WELWYN HATFIELD COUNCIL – DEVELOPMENT CONTROL
DELEGATED REPORT

APPLICATION No:	S6/2010/0298/FP
------------------------	------------------------

The proposed development would involve the erection of a brick wall, with piers, stone copings and stone spheres. The proposed wall would have a height of approximately 1.2m and the piers would have a height of 1.8m to the top of the stone spheres. The proposed gates would have a maximum height of approximately 2.1m and be hung from pillars with a similar height.

CLIENT DESIGN SERVICES LIMITED. 8 Timberdene Avenue, Barkingside, Essex, IG6 2LS. Tel. 020 8550 3320	PLANS AND ELEVATIONS OF NEW WALL AND GATES.	Date	Feb. 2010
	PROPOSE GARDEN WALL EXTENSION AND NEW GATES	Scale	1:100 & 1:25 @ A3
	45 KENTISH LANE, BROOKMANS PARK, AL9 6NG	Dgn. No.	C10/22/04 A

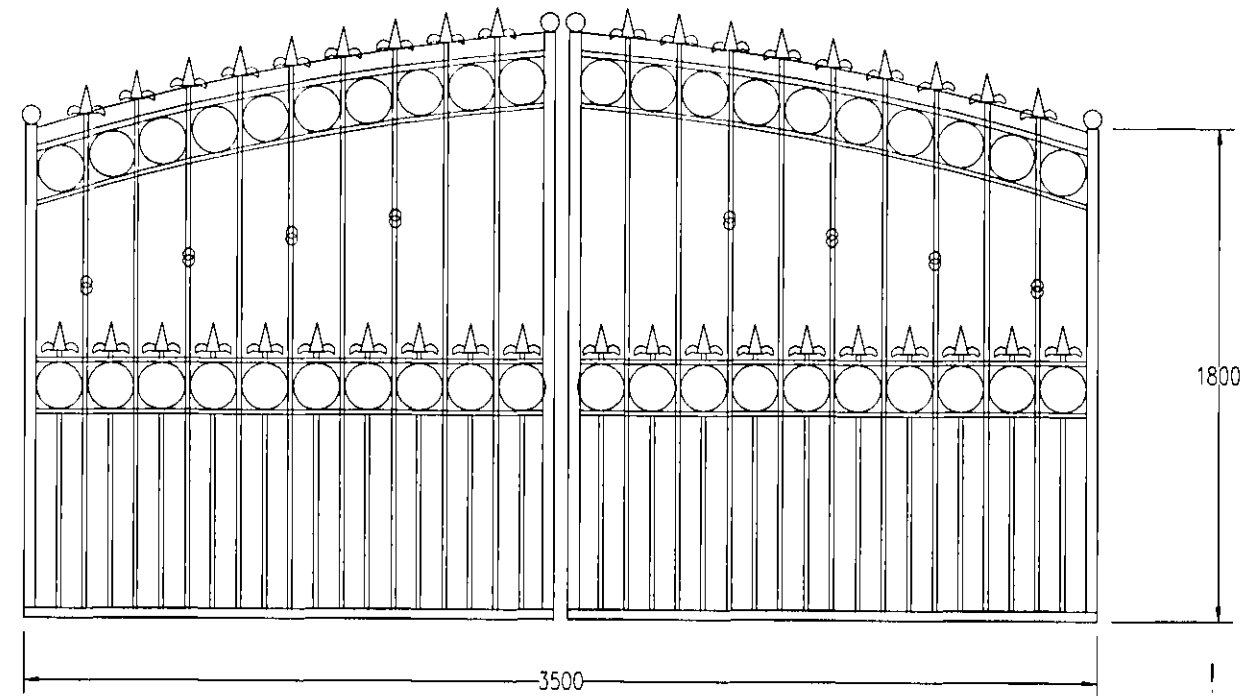
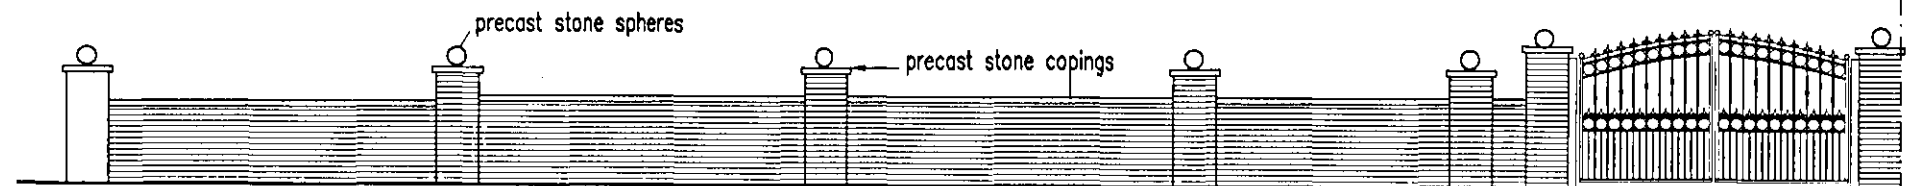
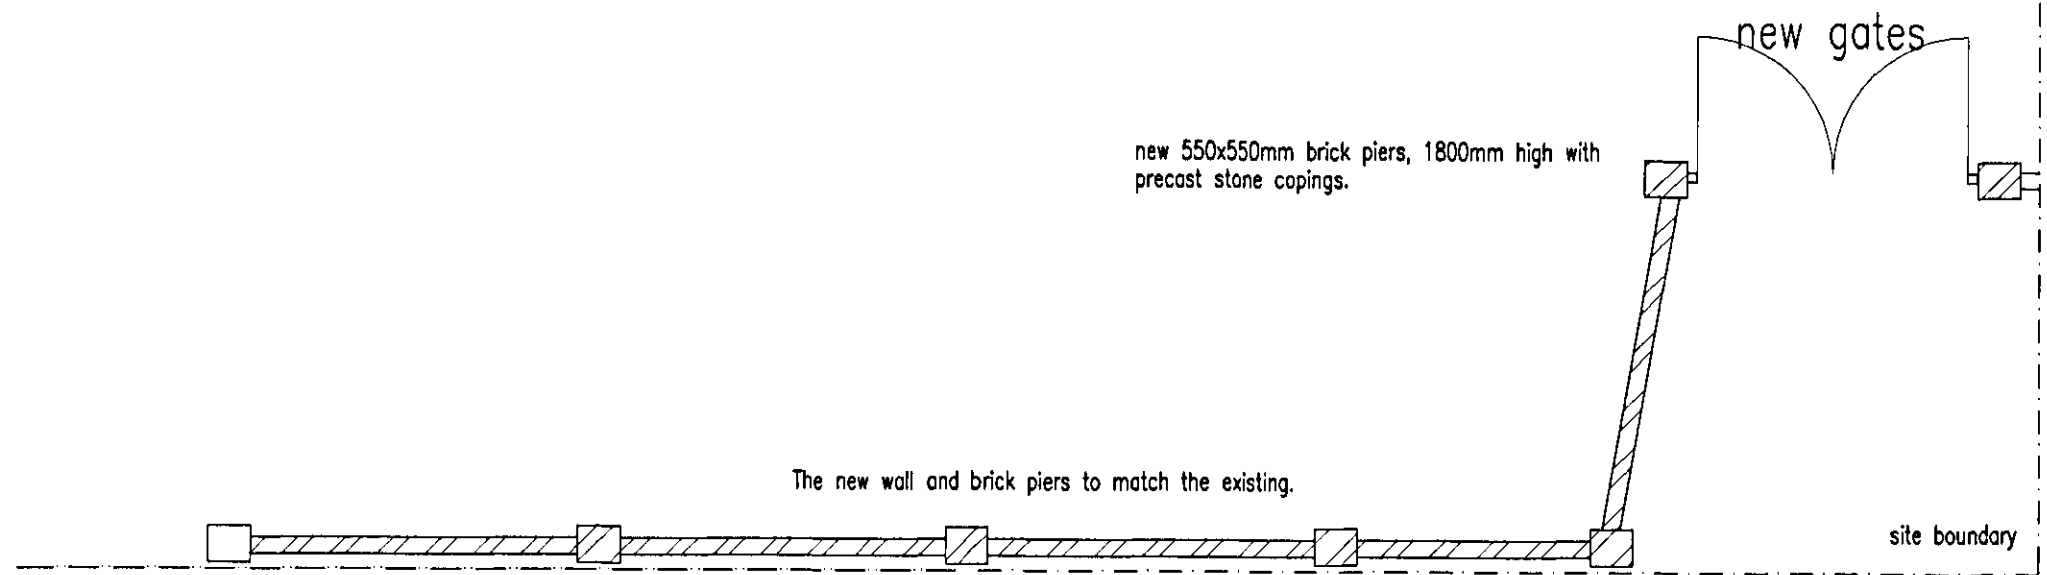
It has been acknowledged that when viewed in isolation the proposed boundary treatment appears balanced and in proportion. However, the proposed development would introduce a tall and dominant structure to the front boundary, which would be particularly urban in character. This boundary treatment would not appear in keeping with the existing and surrounding front boundaries and would be excessively prominent when viewed from the surrounding areas. The proposed railings, gates, pillars and ornate design are all not features that characterise the locality. The proposed boundary would appear incongruous due to the proposed height and design and would not harmonise with natural features of the street scene, which are considered to be desirable.

The proposed development would form additional development within a prominent position on the application plot. The existing boundary wall appears to have been erected some time ago and does not have a planning history. The proposal would have a harsh appearance and not be in keeping with the well landscaped surroundings, which maintain the open character and appearance of the area.

The proposal would involve an extension of the existing boundary treatment and alterations which would have a more prominent design. The proposed boundary treatment and gates would appear far more urban in character than the existing frontage. An additional wall is not appropriate and would be much more noticeable than the existing. This urbanising affect of the proposed development would be worsened by the height of the proposed gates and ornate design. The proposed development would therefore have an adverse impact upon the openness of the Metropolitan Green Belt.

The proposed boundary development would appear overly prominent and dominant by reason of the proposed height, design, siting and overall incongruous appearance. The proposal would fail to maintain the openness of the Green Belt and would have an urbanising impact upon the plot and surrounding area. The proposal would therefore fail to appropriately reflect the existing character and appearance of the surrounding street scene and have a detrimental impact upon the visual amenity of the locality. The application has therefore failed to meet the requirements of PPS1, PPG2 and Policy D2 of the Welwyn Hatfield District Plan 2005.
